STATE OF NORTH CAROLINA
DEPARTMENT OF TRANSPORTATION

July 8, 2004

SUBJECT: **Permit Modification Request for TIP No. R-2231B**, Richmond County,
Federal Aid No NHF-45-1(49), State Project No. 8T550803, NCDOT
Division 8, \$475.00 Debit work order 8T550803, WBS Element No.
34398.1.4, NCDOT Division 8

The North Carolina Department of Transportation (NCDOT) proposes to modify the construction plans for the abovementioned project. The purpose of this letter is to request a modification to the Department of the Army Individual Permit, as well as to the 401 Water Quality Certification from the NC Division of Water Quality. A new set of permit drawings are attached.

SHEET 28 OF 43

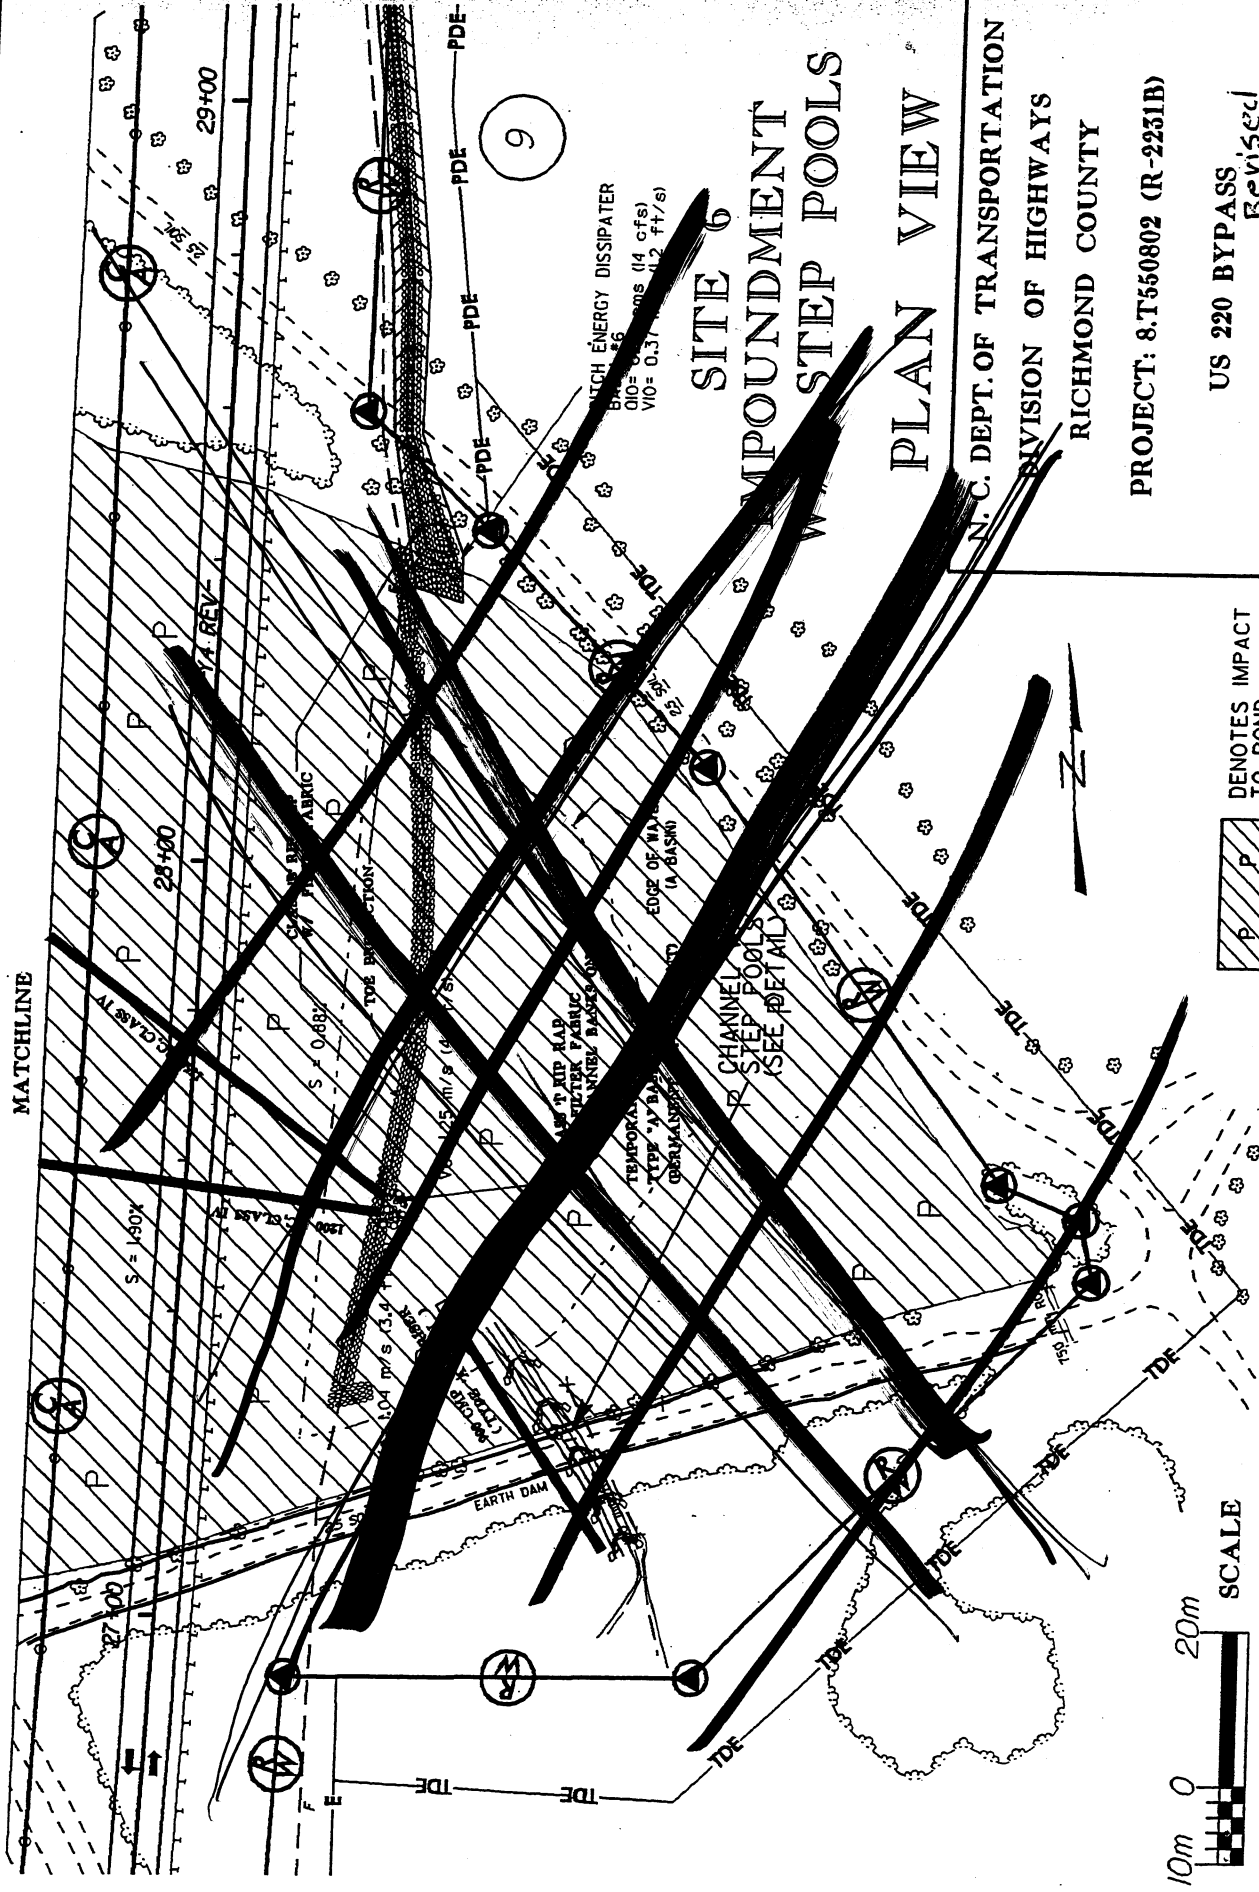
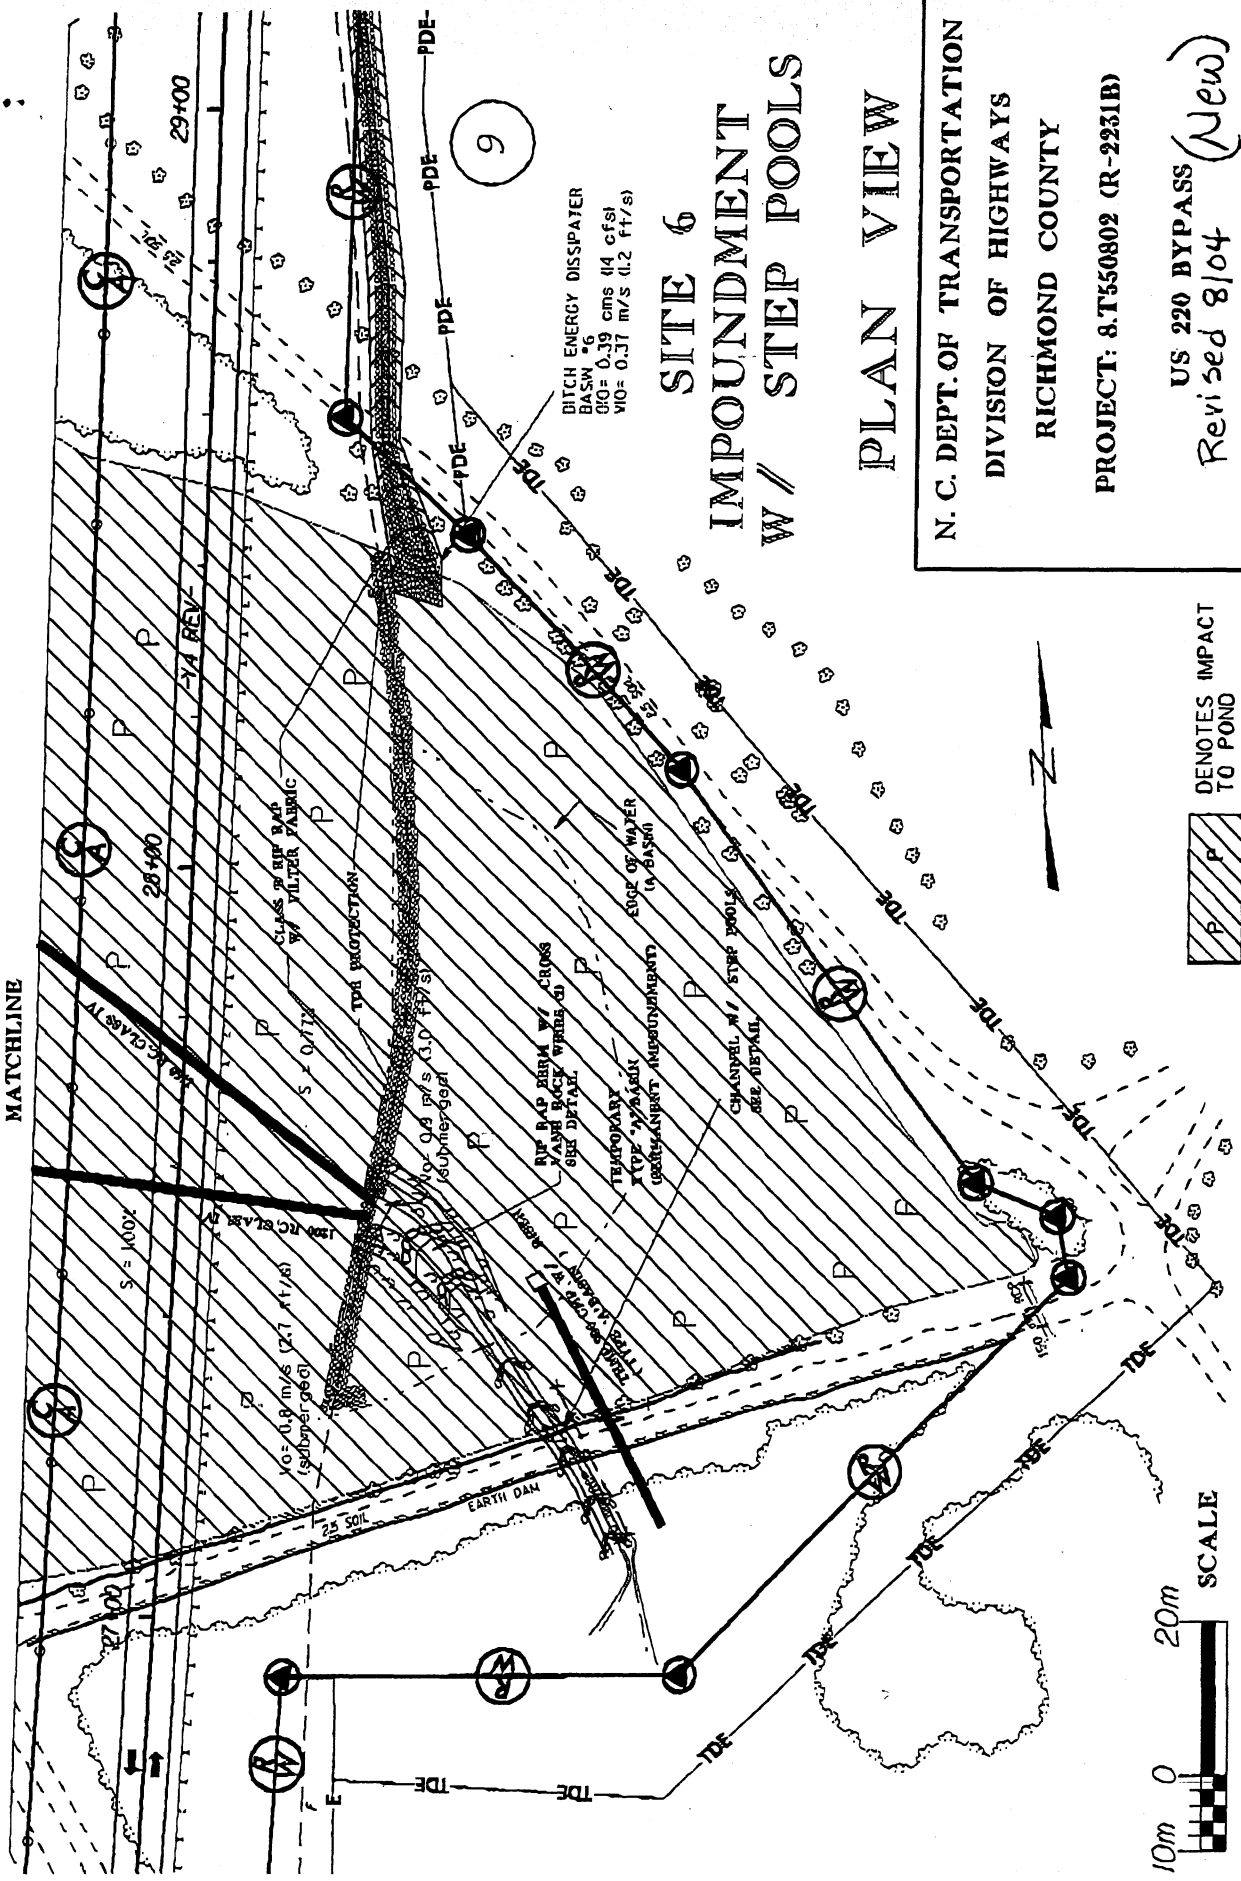
Site 6, Sheet 28 of 43

Station 140+20 TO Station 141+40-L-(Rt)

Eliminate the stream relocation design below the proposed roadway. A step-pool channel is proposed through the dam to stabilize this site. See attached hydraulic plans and supporting data.

Mitigation change: elimination of 249 linear feet of Natural Stream Design
